Consultation Response from KC Highways Development Management
2019/93646 Elmleigh Farm Cottage, Stringer House Lane, Emley Moor, Huddersfield, HD8 9SU
Demolition of existing garage and erection of dwelling
Date Responded: 02/12/19 | Responding Officer: J Turner | Responding Ref: K17-25/7

This application seeks approval for the demolition of an existing garage and the erection of a dwelling at Elmleigh Farm Cottage, Stringer House Lane, Emley Moor.

Site Plan
1 : 200

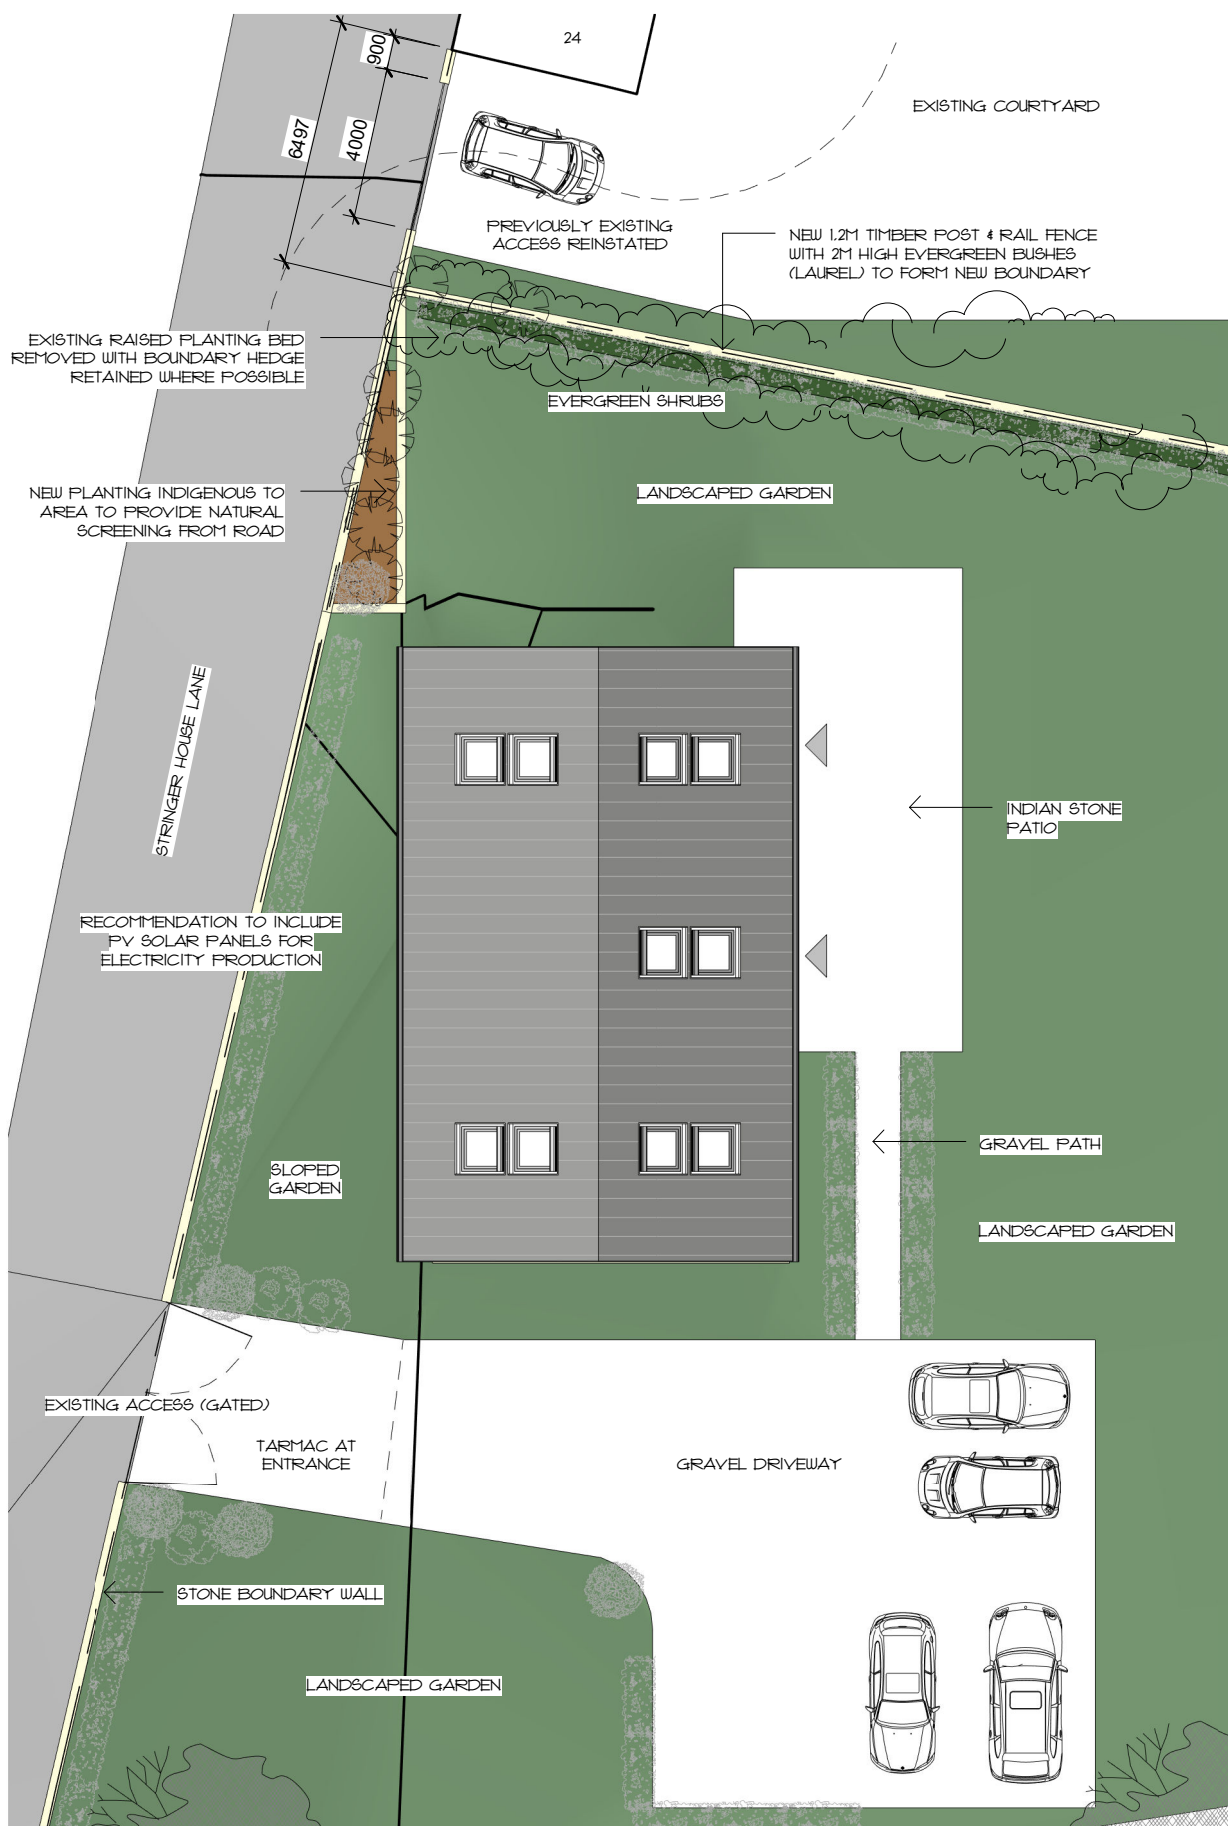
This proposal provides a 4 bedroom dwelling with off-street parking for at least four vehicles.

The proposed conversion will utilize the existing access to number 24 with a new access provided for the use of the existing property.

Given that this proposal provides sufficient off-street parking facilities these proposals are considered acceptable from a highways perspective. If planning is minded to approve this application the following conditions should be attached to the Decision Notice:

Nothing shall be permitted to be planted or erected within a strip of land 2.0m deep measured from the carriageway edge of Stringer House Lane along the full frontage of the site which exceeds 1.0m in height above the level of the adjoining highway.

Prior to the development being brought into use, the approved vehicle parking areas shall be surfaced and drained in accordance with the Communities and Local Government; and Environment Agencies 'Guidance on the permeable surfacing of front gardens (parking areas)' published 13th May 2009 (ISBN 9781409804864) as amended or superseded; and thereafter retained throughout the lifetime of the development.
